City of Portland, Maine - Building or Use Permit Application
389 Congress Street, 04101 Tel: (207) 874-8703, Fax: (207) 874-8716

Permit No: 02 0972	Issue Date: SEP - 4 2002	CBI: 298 D004001
-----------------------	-----------------------------	---------------------

Proposed Project Description:
Add 12' x 12' Breezeway

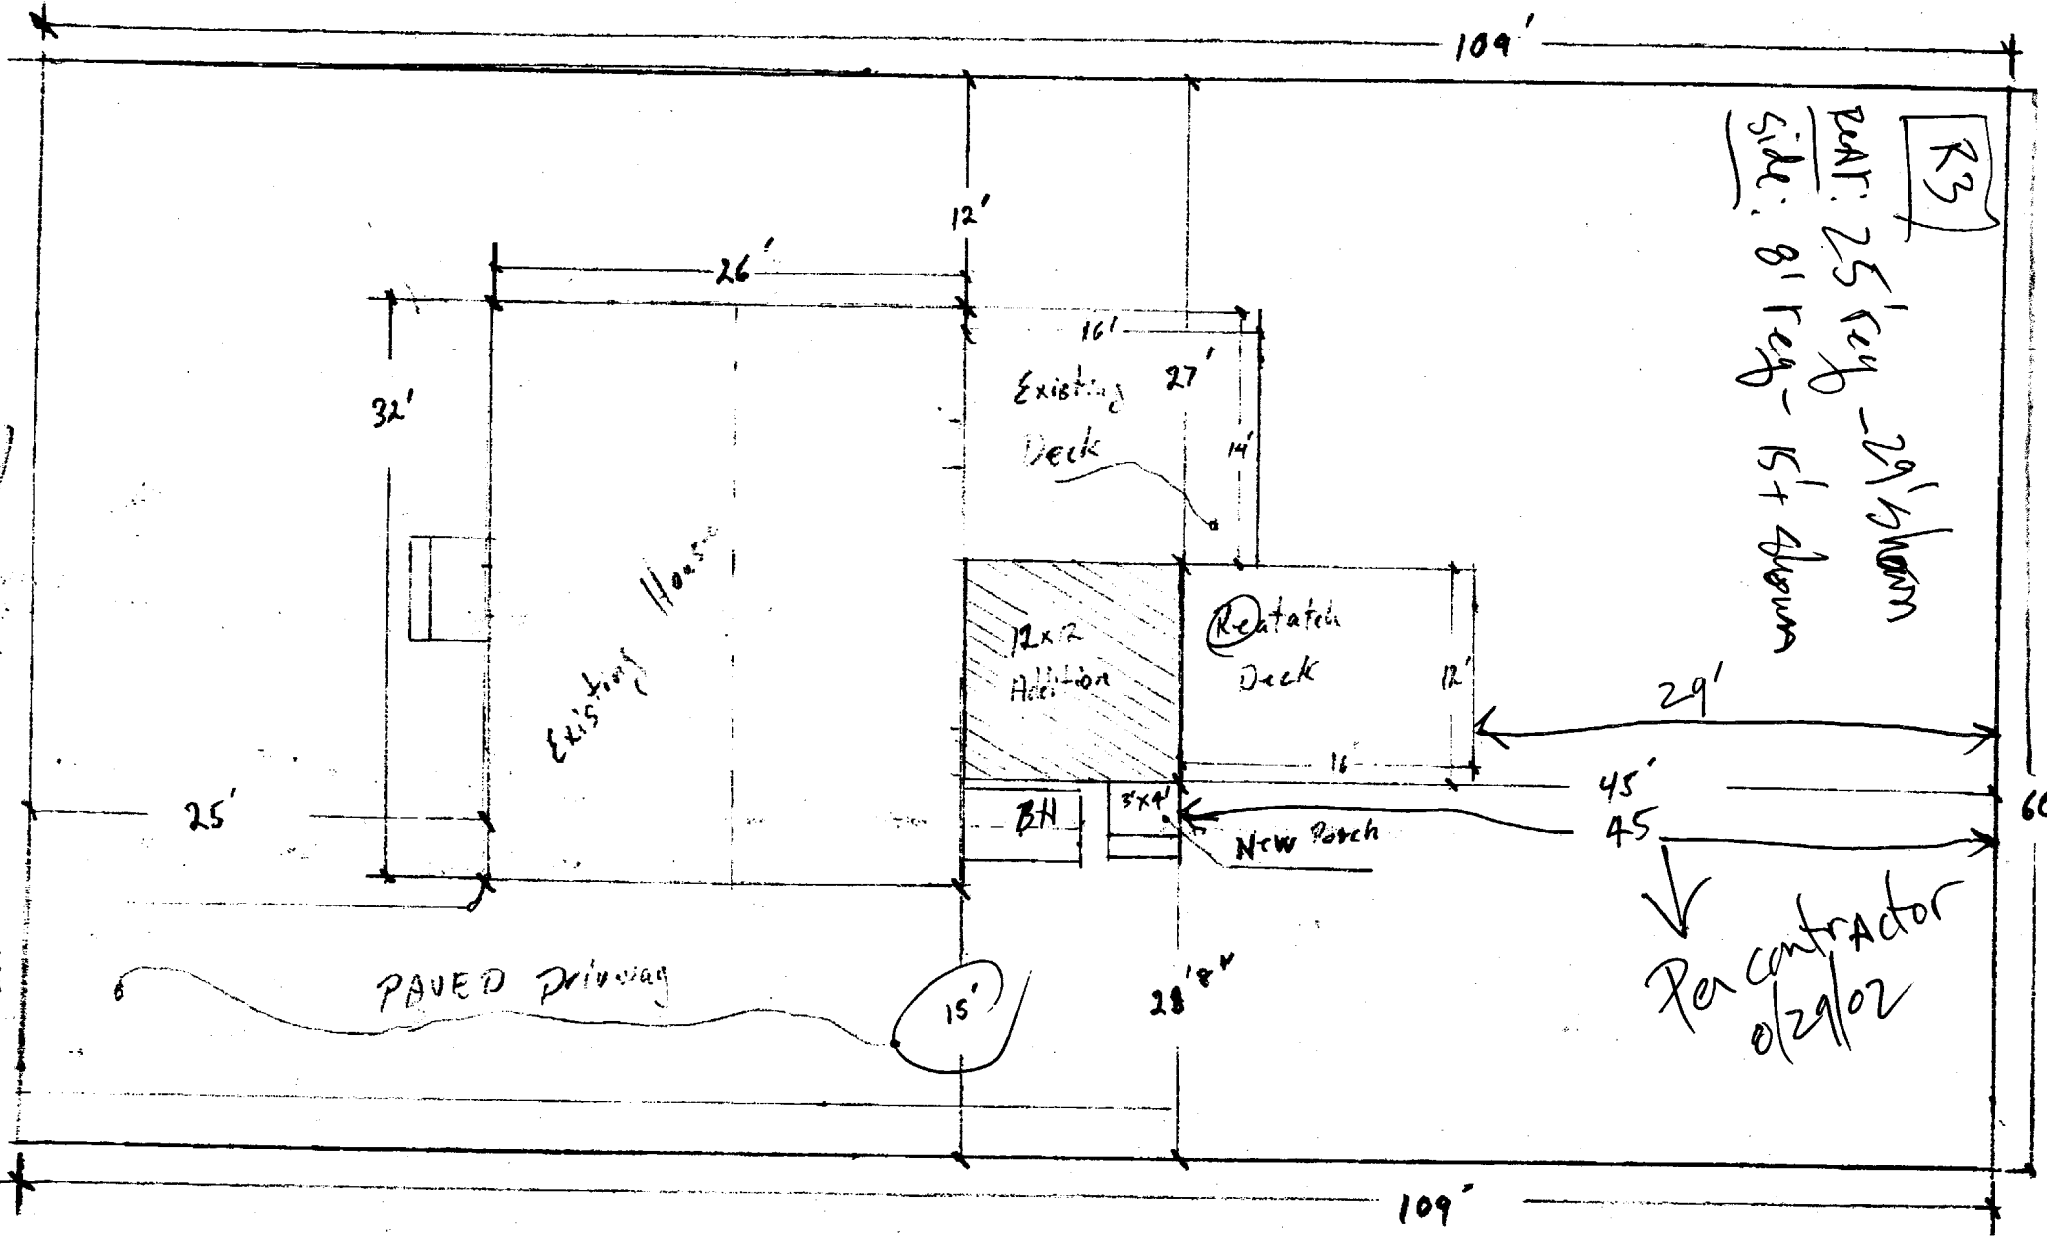
R3
 PAT: 25' req - 29' shown
 Side: 8' req - 15' shown

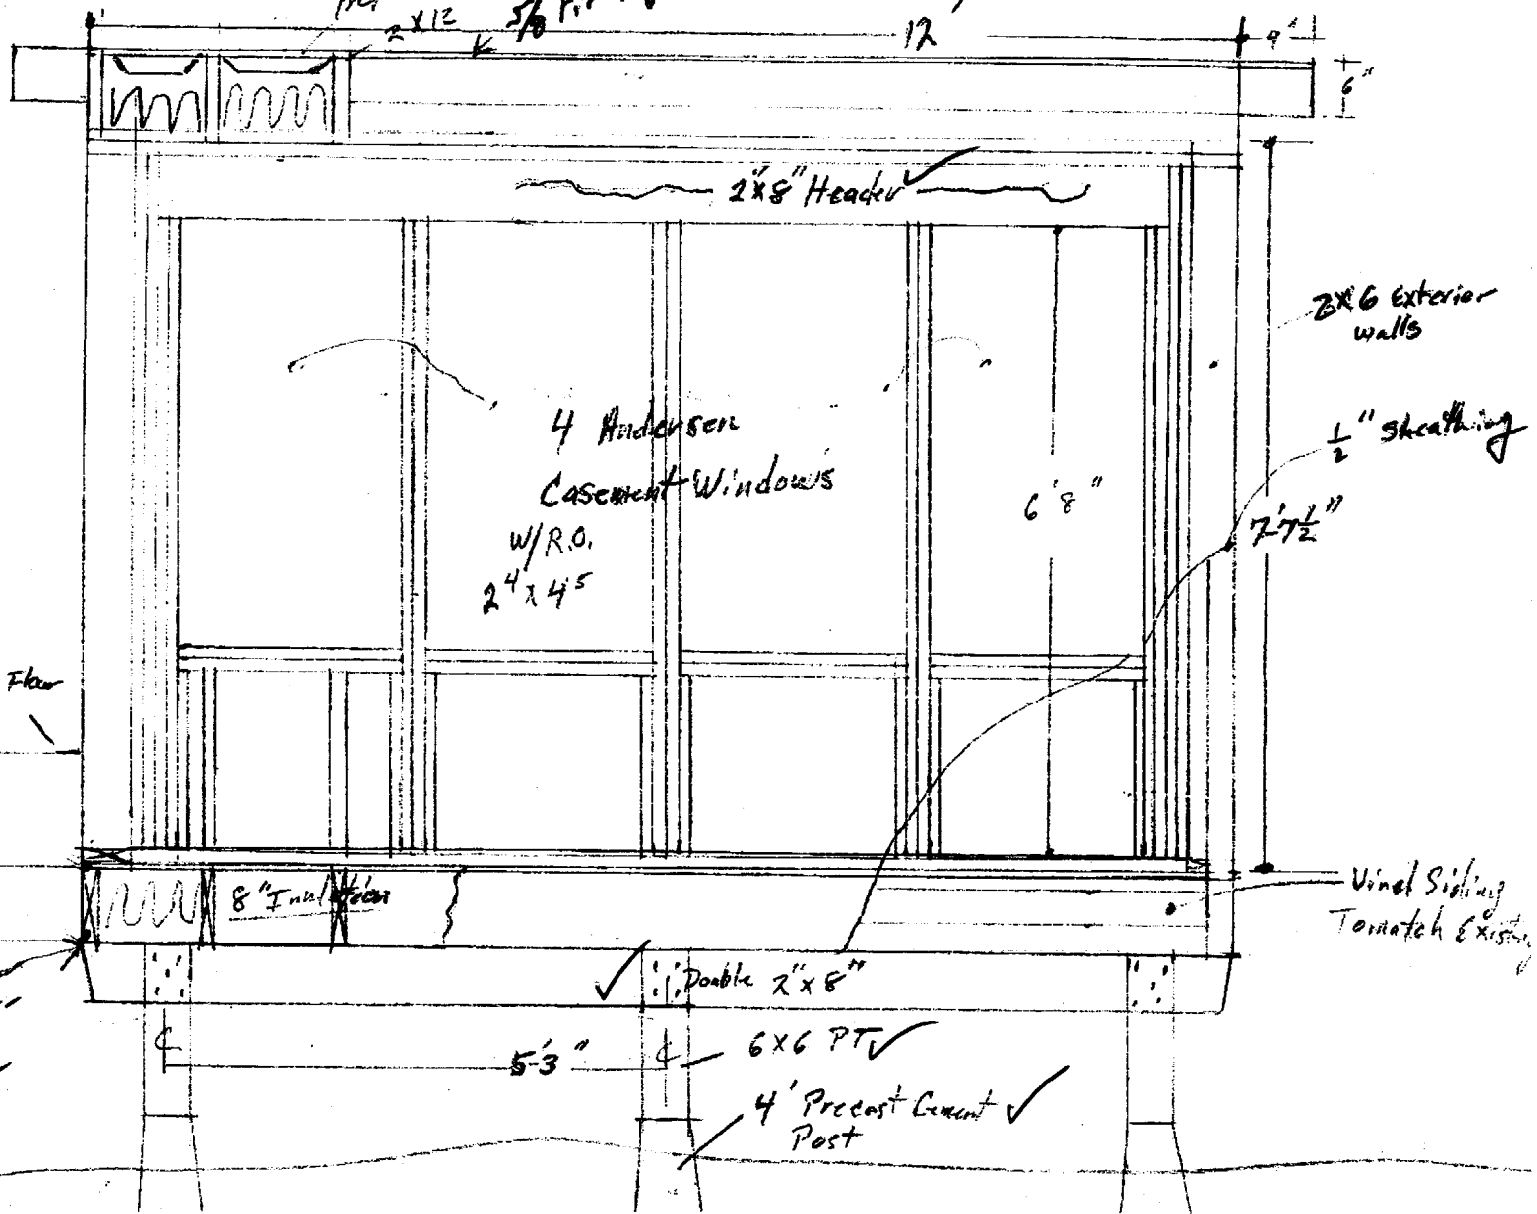
doesn't add up to 109'
something is off by 15'
